Arun District Council
Arun Civic Centre
Maltravers Road
Littlehampton
West Sussex BN17 5LF
Planning General Enquiries
Tel: (01903) 737756 Fax: (01903) 730442
Dx: 57406 Littlehampton
Minicom: 01903 732765
e-mail: planning@arun.gov.uk
website: www.arun.gov.uk/planning

Town & Country Planning Act 1990 (as amended)
Town and Country Planning (Development Management Procedure) (England) Order 2015
Approval of details reserved by condition imposed under ref LU/229/10/ relating to Condition No 16
all the existing trees/bushes/hedges to be retained on the site have been protected by a fence.
Windroos Nursery And Land Adjoining Worthing Road, Littlehampton,

Arun District Council have decided to **APPROVE details reserved by this condition**

Barrell Plan Ref: 15110-BT1

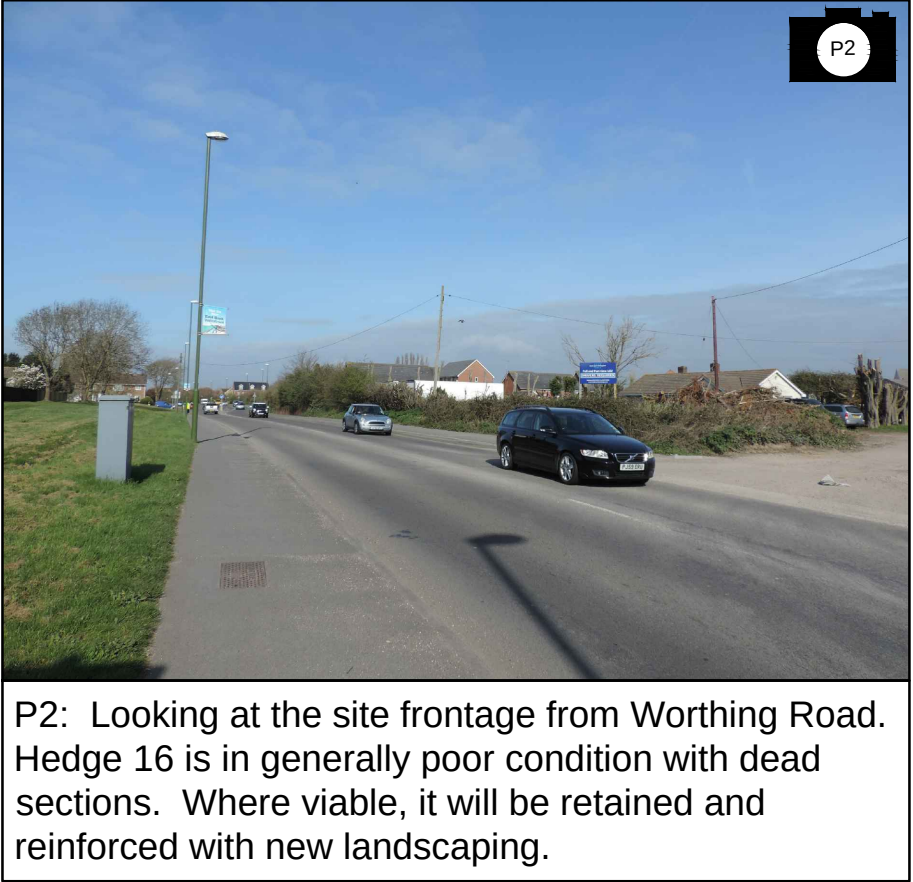
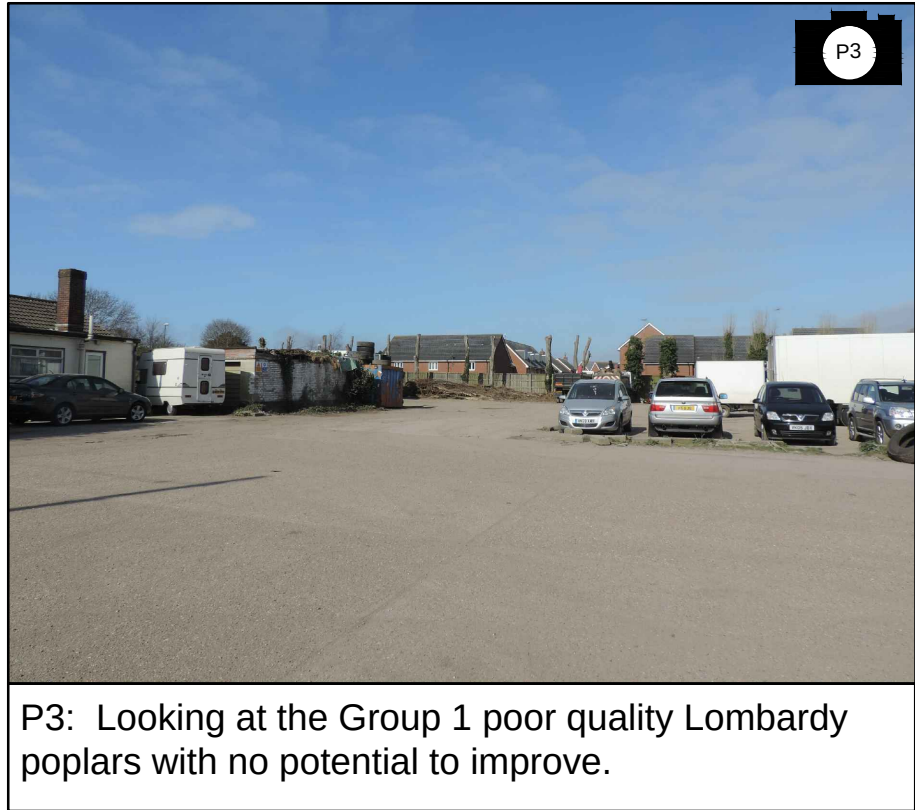
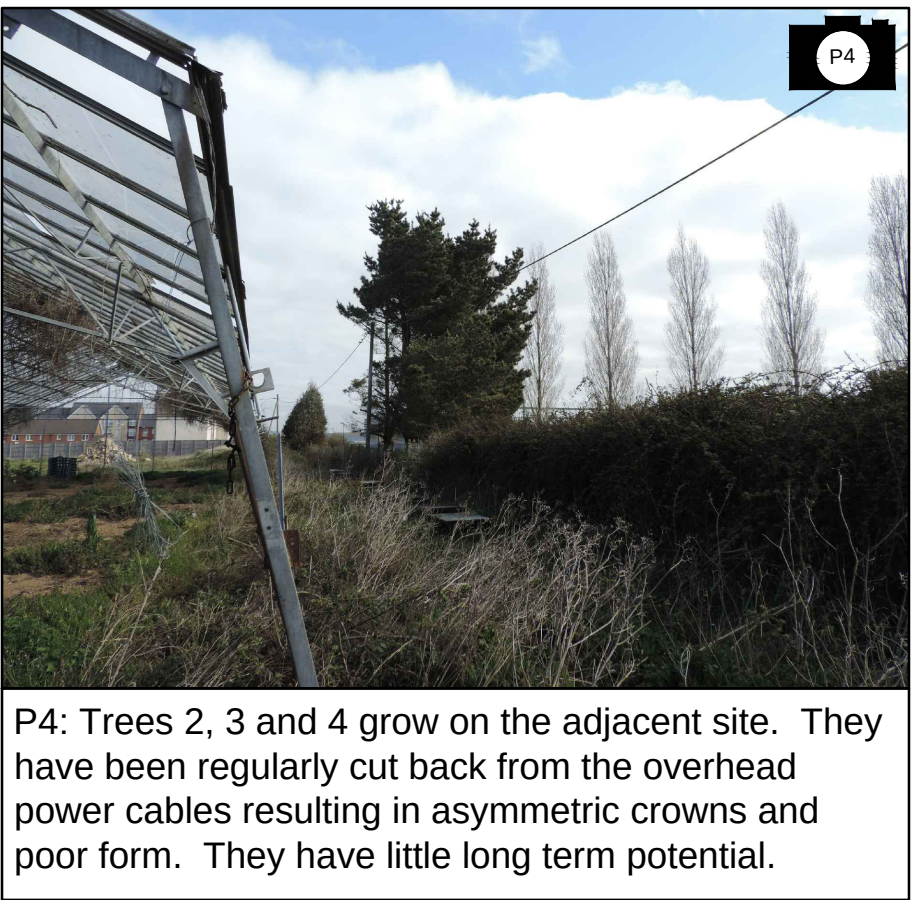
- The fencing associated with the Hawthorn Hedge (H17) on the north western boundary, must have tree protection fencing extending 5m from the base of the trees.*
- The Oak Tree (T11) must be protected with adequate fencing according to the BS5837 (2005) by providing substantial fencing to a distance of at least 5.5m.*
- The three Monterey Pines (G16) to the east of the eastern boundary should not be cut to the fence boundary as proposed by the Ecourban consultants.*

The details of the tree protective fencing shall be erected prior to development commencing in accordance with Tree Protection Plan (TPP), Ref. 022.1832 & 13121 P.10.010 C, Barrel Plan Ref 15110-BT1 and shall be retained as such for the period of construction.
